Ribble Valley Borough Council
By email

Your ref: 3/2022/0396
Our ref: DC/22/1607
Date: 24-MAY-22

Location: Eaves Hall Eaves Hall Lane West Bradford BB7 3JG.
Proposal: Variation of Conditions 14 (Drainage) of 3/2020/0544.

DRAINAGE

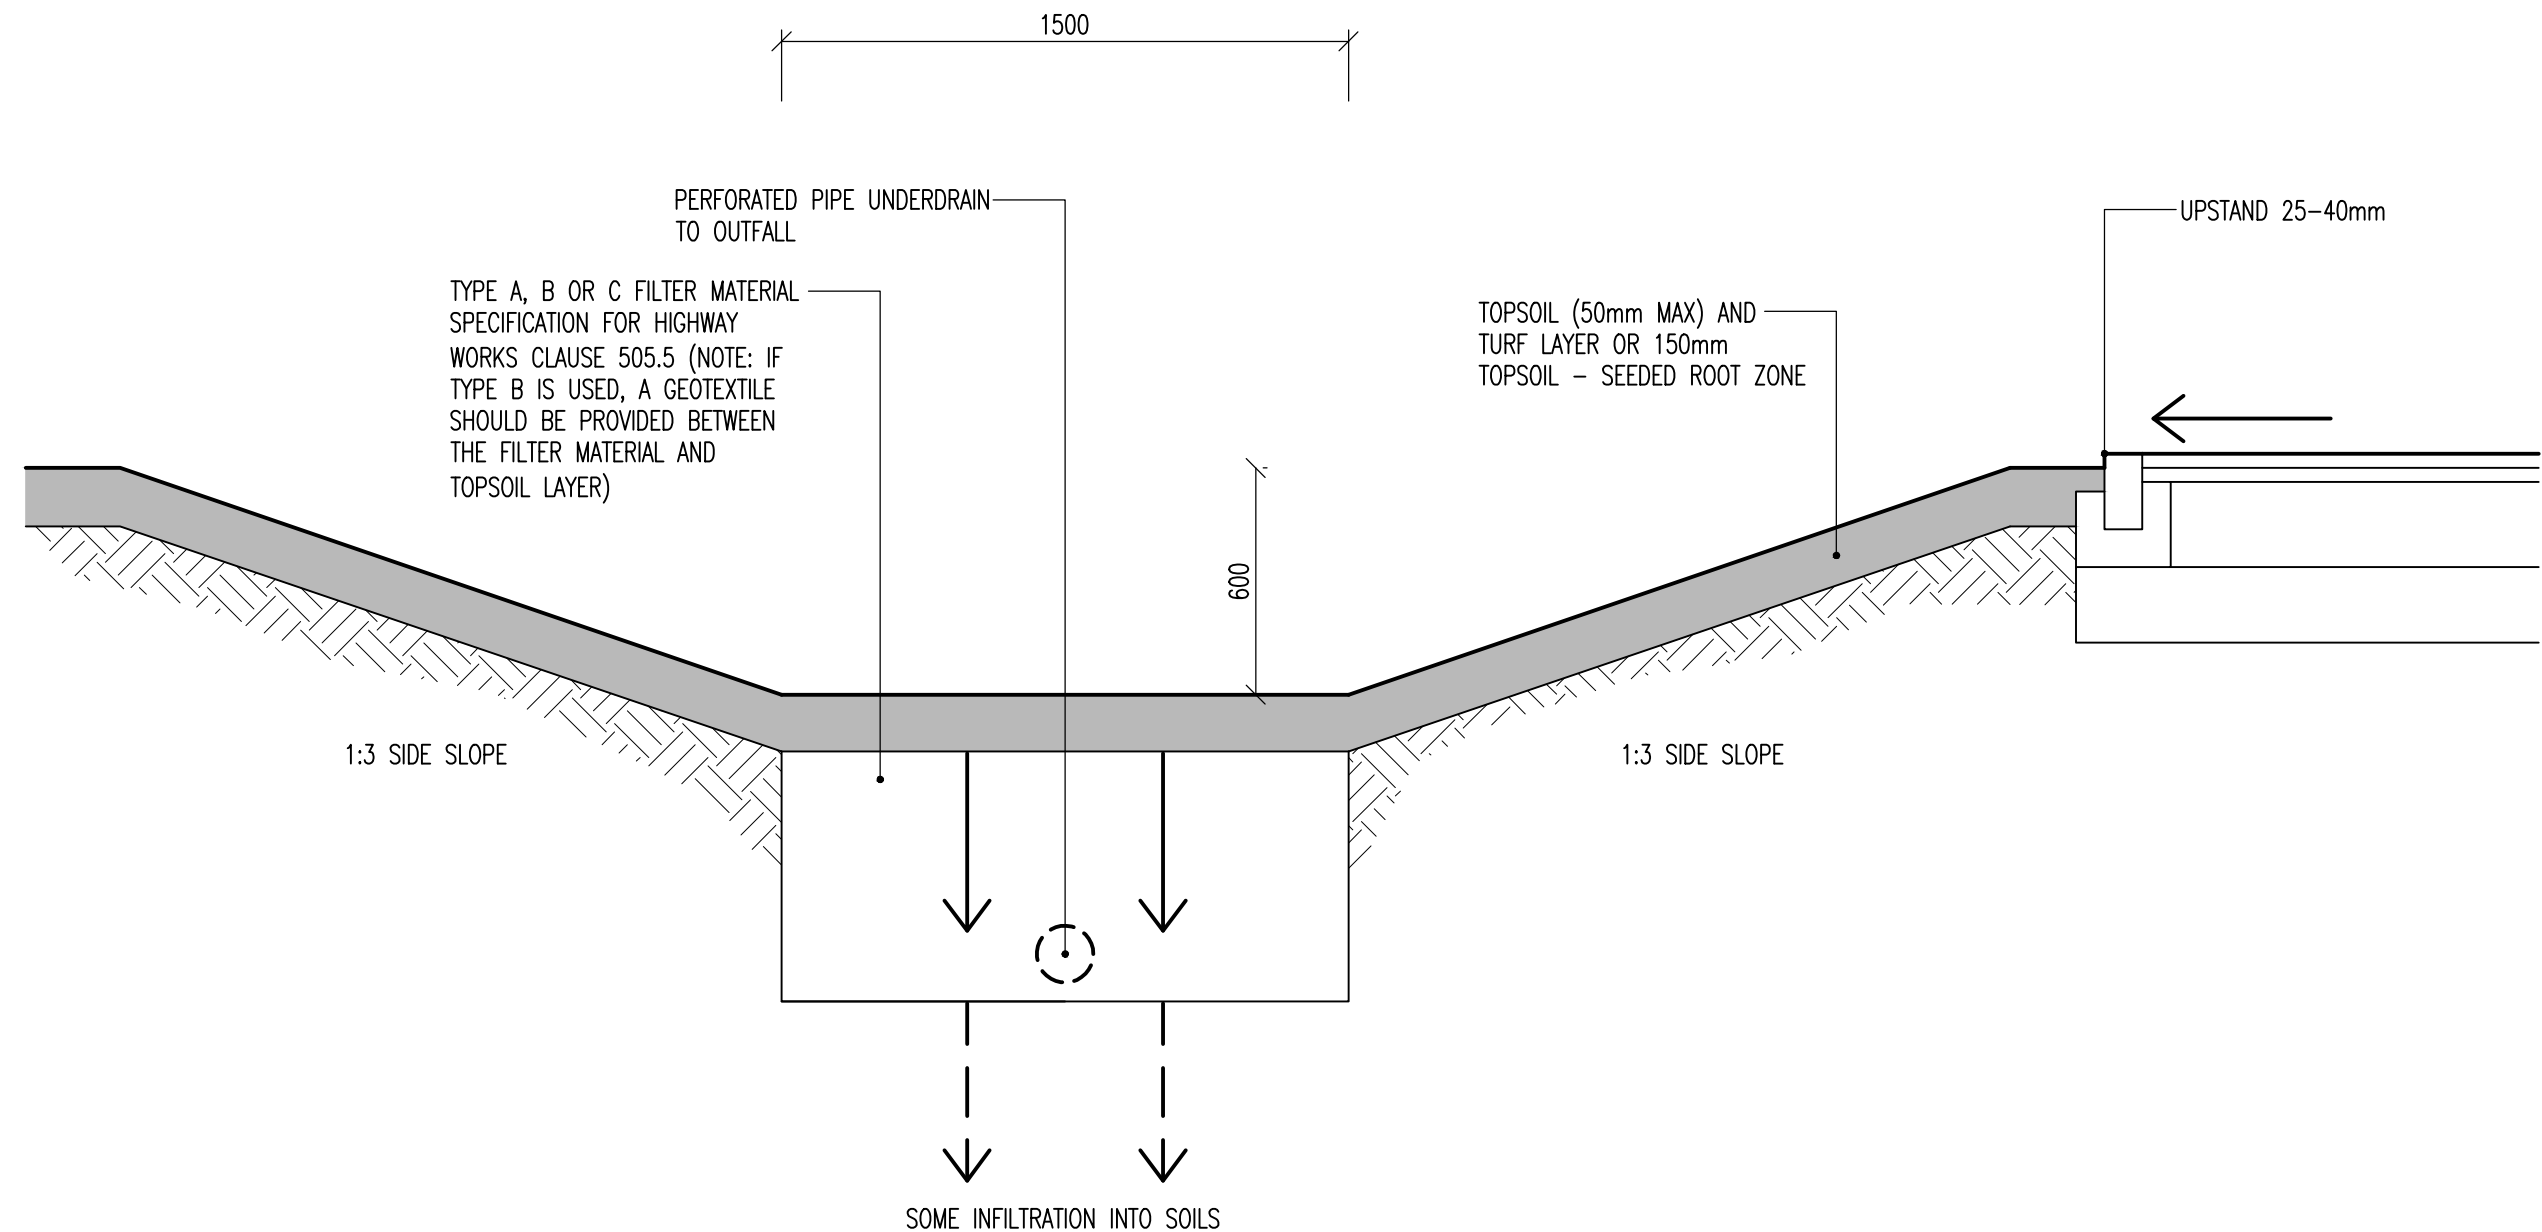
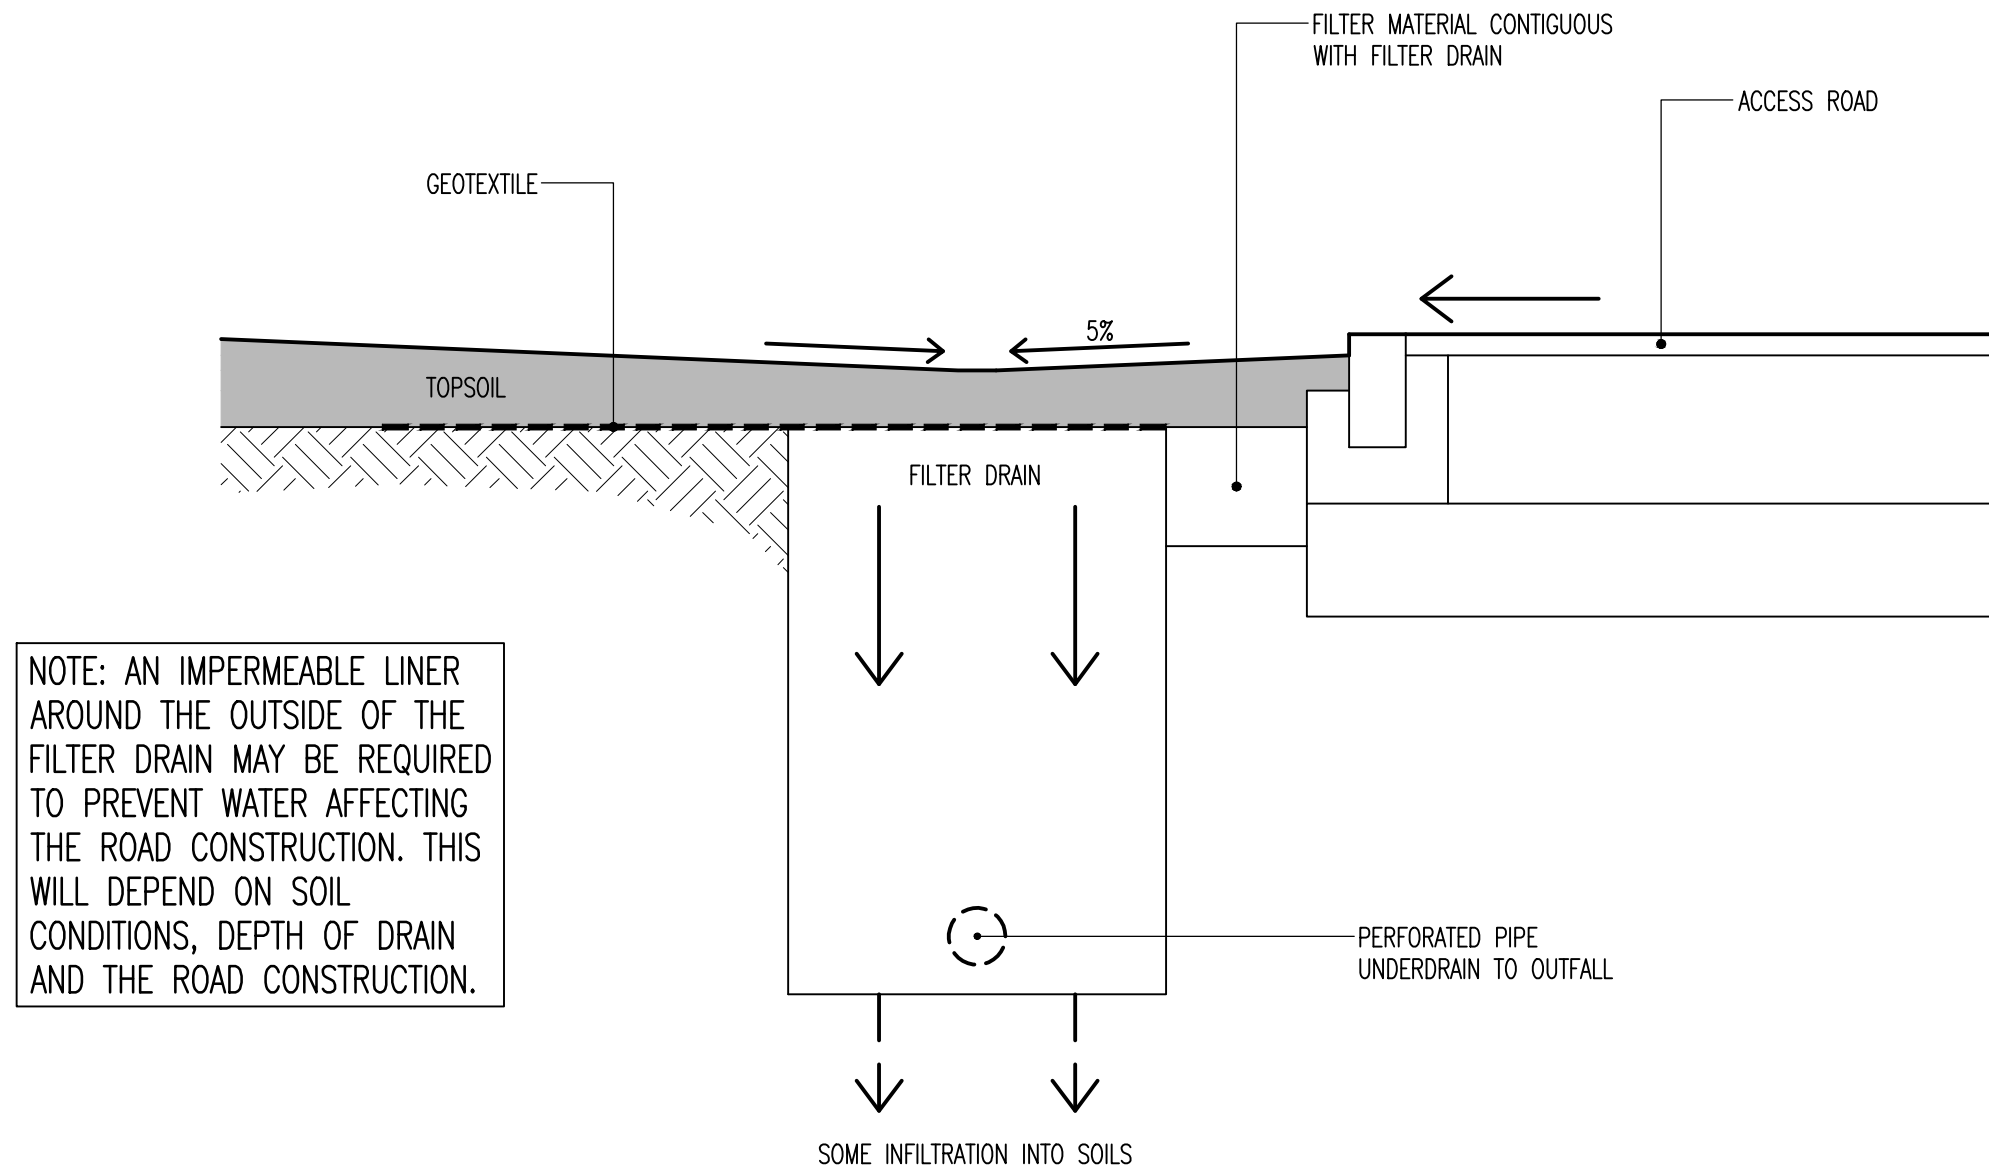
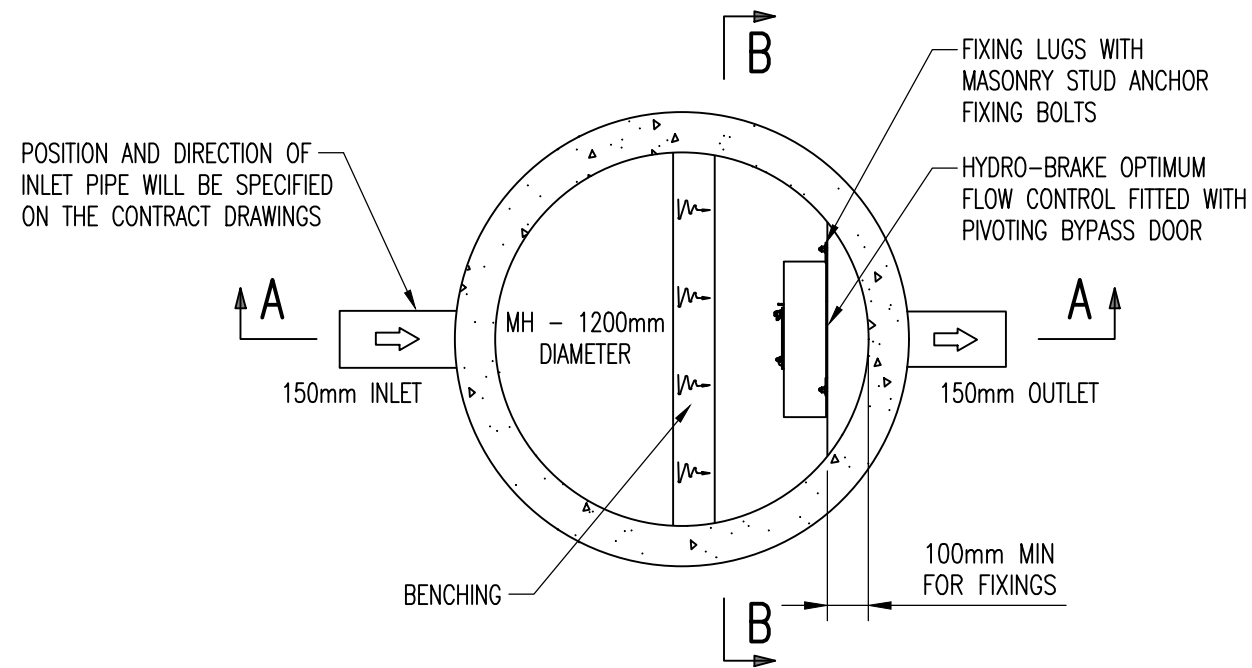
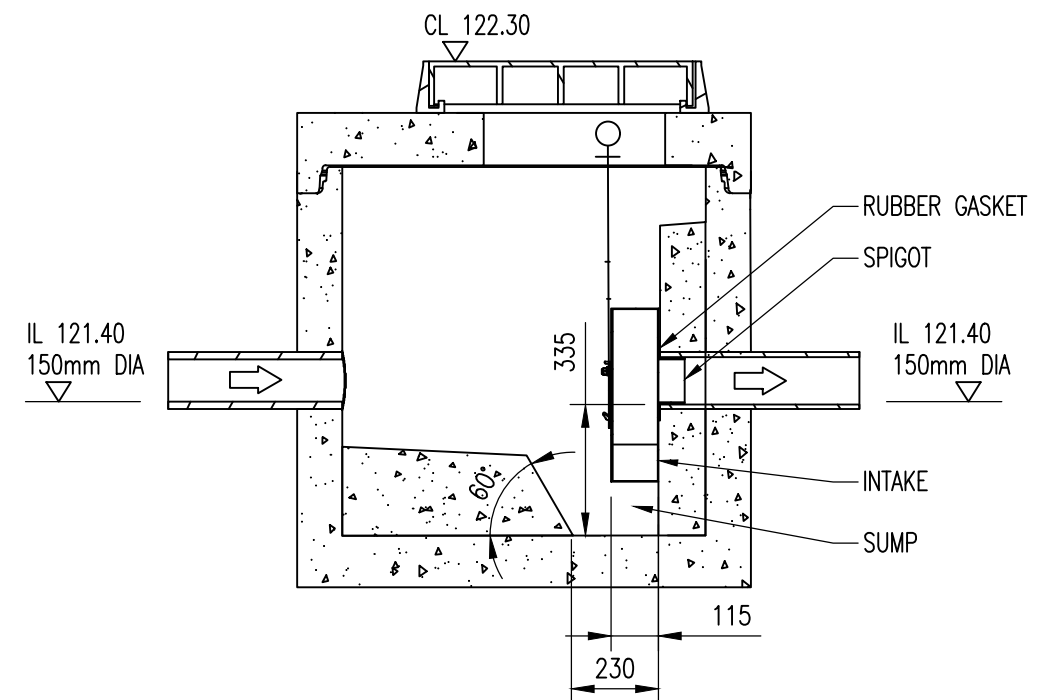
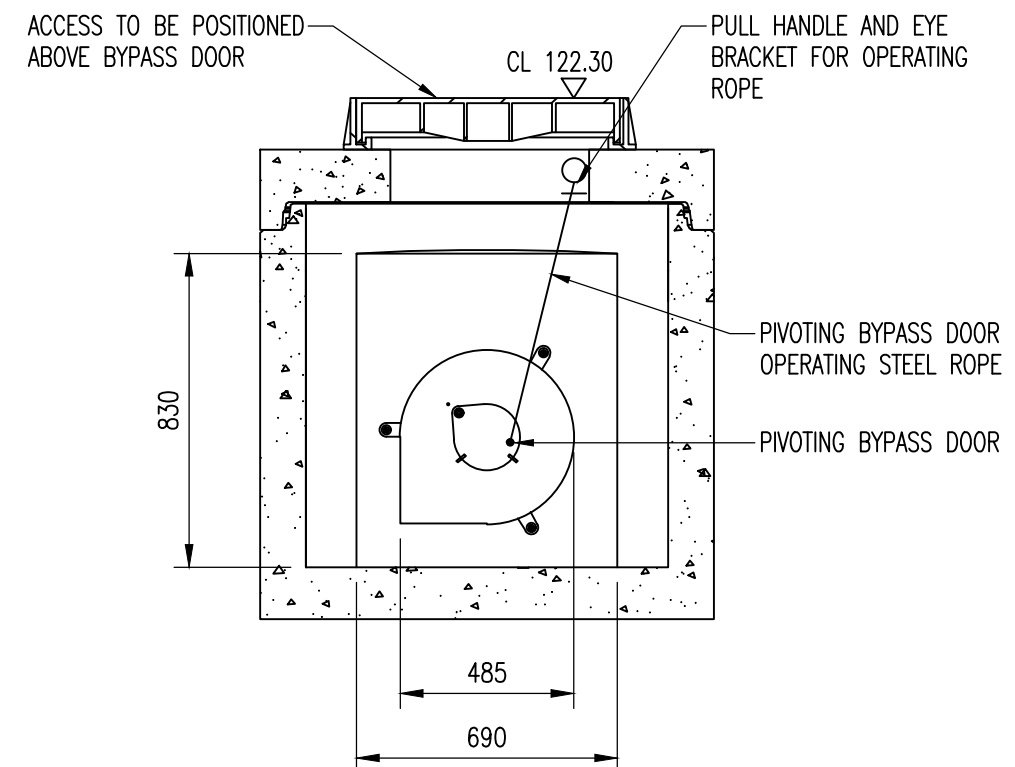
Further to our review of the submitted documents, Drawing 102, Rev P1 - Dated 06.09.21, United Utilities has no objection to condition 14 being discharged.
